**42 Honeysuckle Drive, Newcastle – Amending SSD (SSD-10251)
Response to Submissions**

Having reviewed the submissions and considered the proposal, the Department requests additional information (as set out in **Attachment A**) to progress your application.

Attachment A

General Arrangement Plan
Level 05 Parking
Revision: 10
Date: 04/03/19
Description: Issued for DA Modification

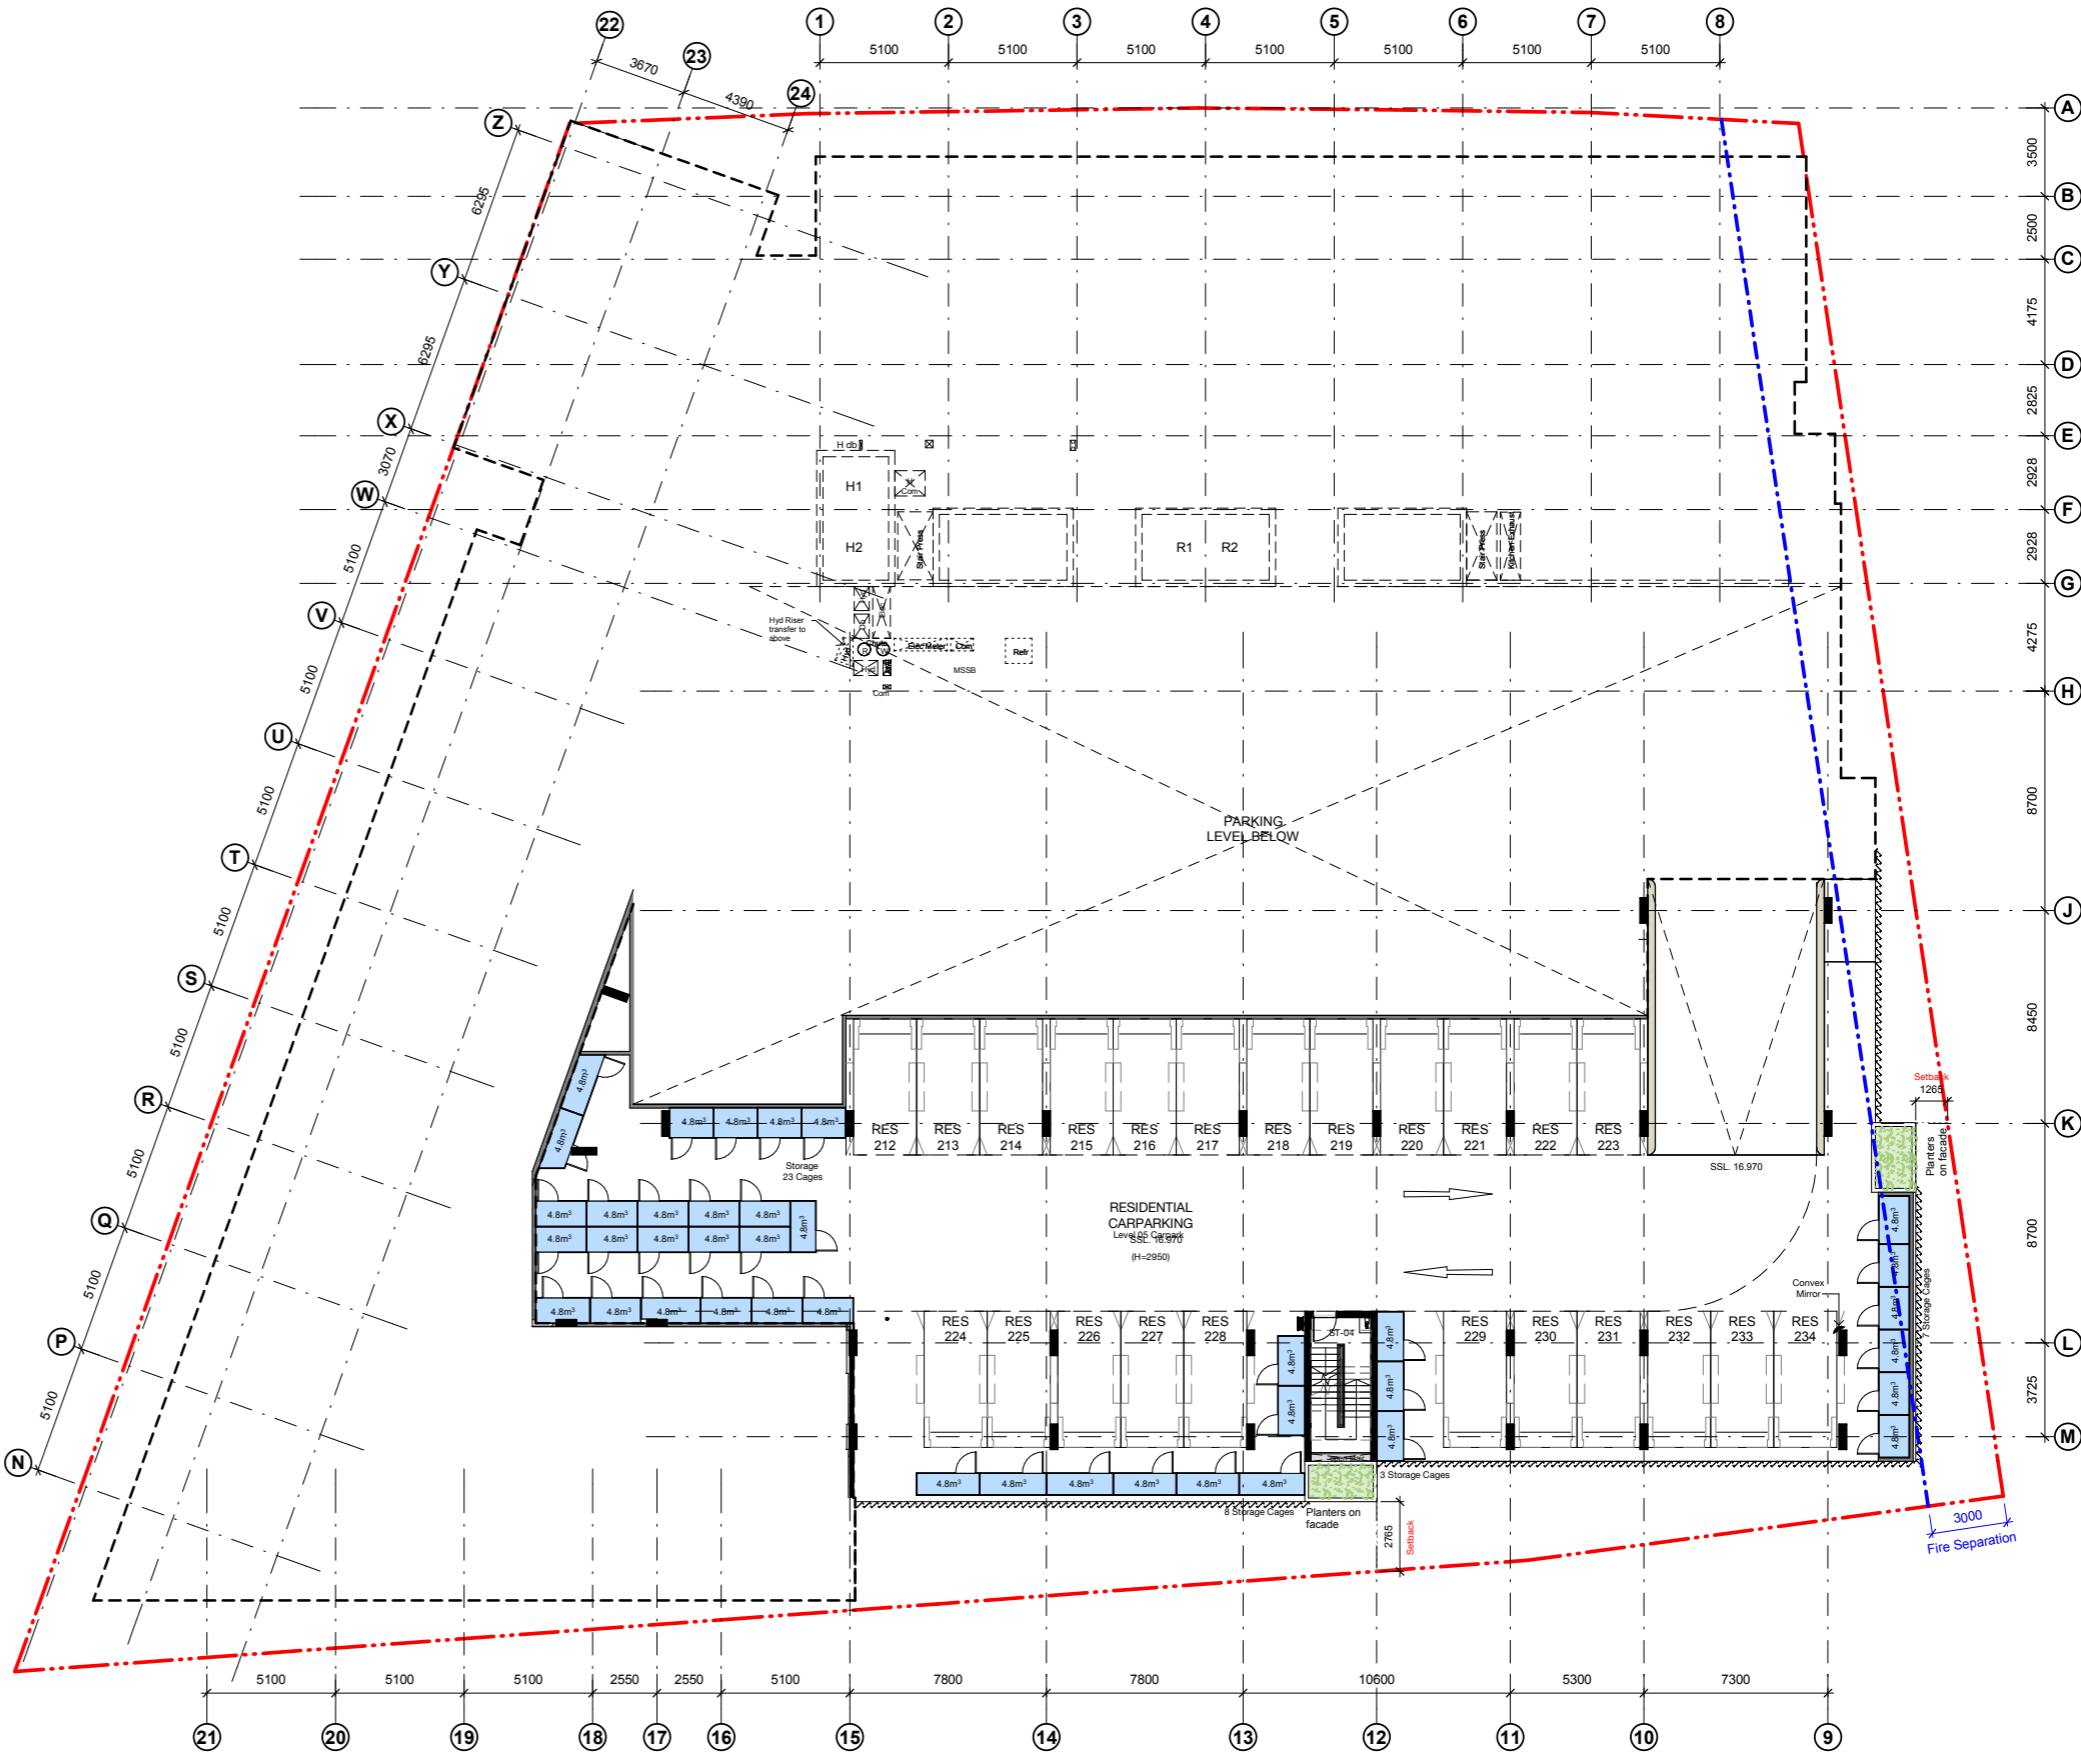
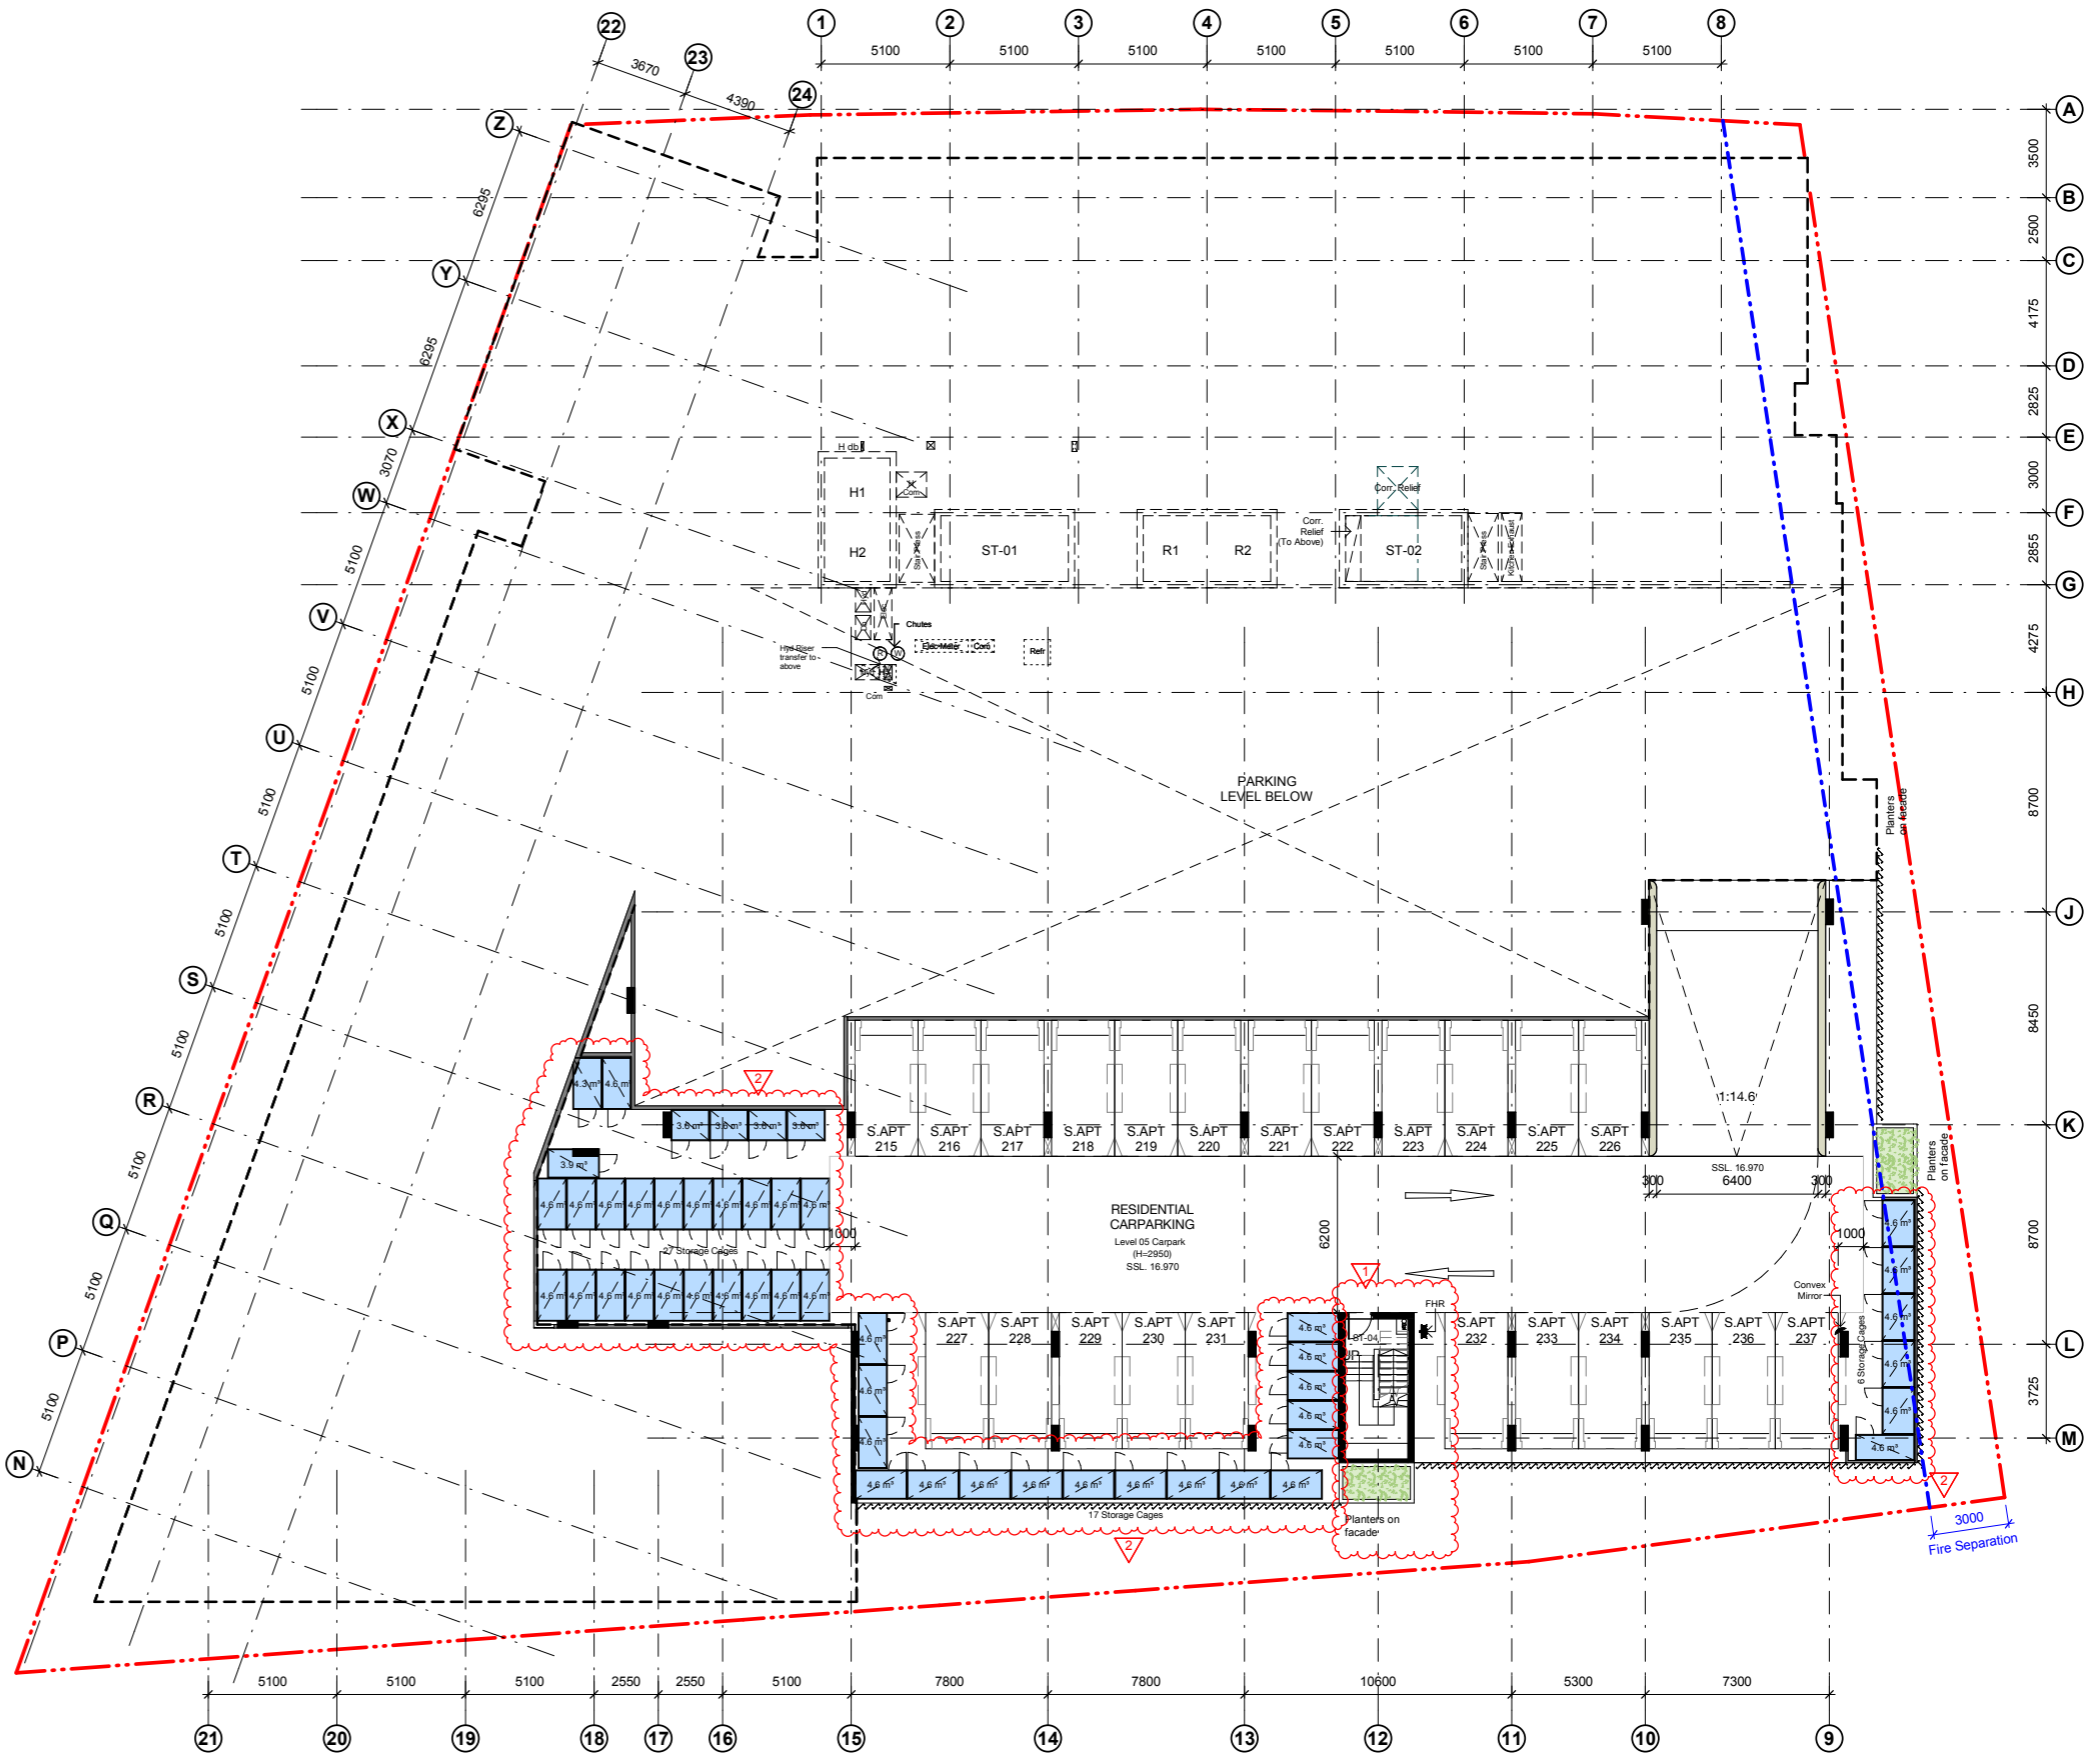
- Please provide an updated Traffic and Parking Assessment which considers the likely traffic impact of the proposed public parking. This should address the proposed increase from 25 to 63 spaces and the proposed flexible use of additional hotel/serviced apartment spaces outside of peak demand times.
